KIRKLEES METROPOLITAN COUNCIL INVESTMENT & REGENERATION SERVICE

DELEGATED DECISION TO DETERMINE APPLICATIONS FOR LISTED BUILDING CONSENT

Reference No:	2025/65/90117/E
Site Address:	Bridge (MDL1/24), Jack Lane, Hanging Heaton, Dewsbury
Description:	Listed Building Consent for replacement of existing bridge deck with a steel and reinforced concrete deck, replacement of existing parapet and repair work to the wingwalls.
Recommending Officer:	Louise Bearcroft

F Proposed Typical Section Through Abutment: Jack Lane Underbridge (MDL1/24)
Scale 1:50

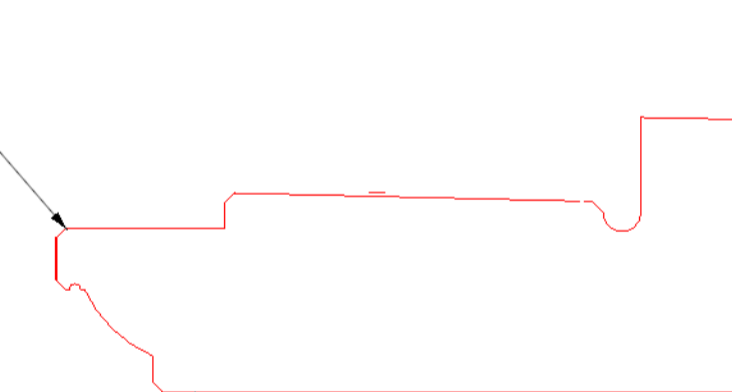
K.C. Conservation and Design also queried the issue of cleaning and whether the proposed jet washing includes the full extent of stonework i.e. all wingwalls and not just under the bridge itself. Network Rail have confirmed this was proposed only to the bridge abutments and areas of repair work. However, should officers have concerns this might leave the structure looking less uniform, then cleaning it is not essential. K.C Conservation and Design have considered this further and are satisfied with the potential for some level of cleaning but to ensure no starkness between the parts of the bridge which are cleaned and those areas to be left, they recommend a condition to secure details of the scope and method of any proposed cleaning to the Listed Structure, including a sample panel/area to be undertaken in the least conspicuous place. This matter can be addressed via imposition of condition.

E Proposed East Elevation: Jack Lane Underbridge (MDL1/24)
042472 SCALE 1:100

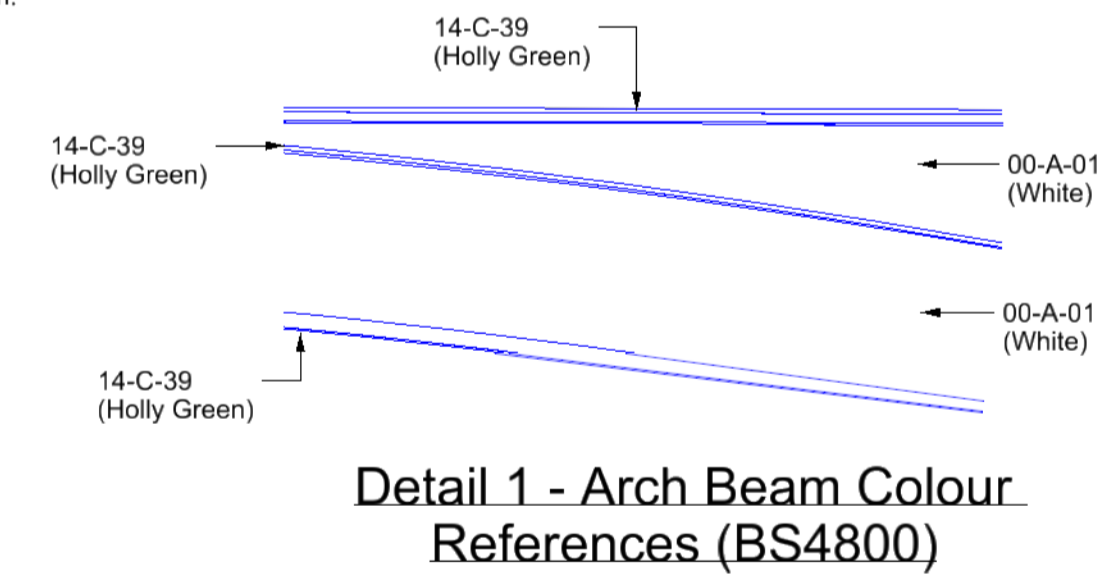
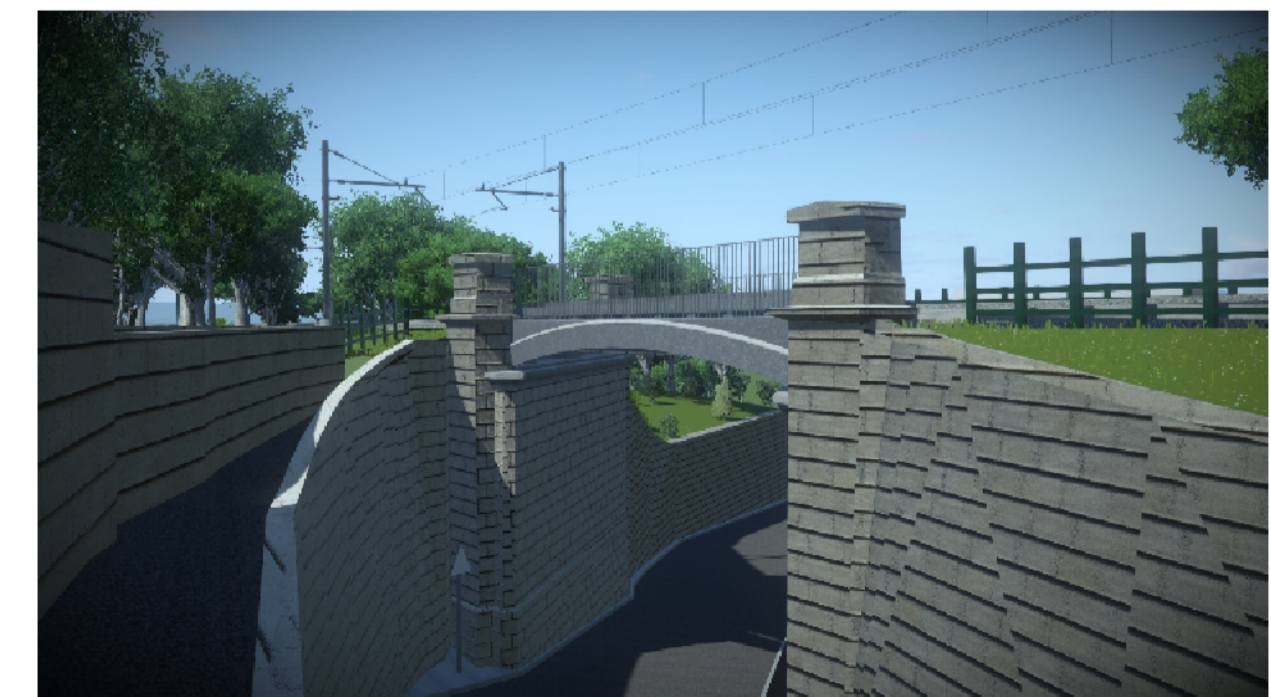
K.C. Conservation and Design support the proposal in principle but initially sought further clarification. They queried if the stone cornice is being lost in its entirety or just a central section to be replaced in concrete and detailed to match. Network Rail have confirmed it will be the central section of each

cornice which is being removed and replaced with concrete, detailed to match the stonework of the cornice. The four corner stones which are visible on the approach to the bridge are being retained. K.C. Conservation and Design are satisfied with this subject to imposing a condition for colour matching of the concrete. This was discussed with Network Rail who raised concerns that an exact colour match could prove difficult and requested the condition didn't require colour matching in circumstances where the dyed concrete appears more out of keeping than a natural finish. Officers have proposed a condition to secure a sample panel, which has been agreed with Network Rail.
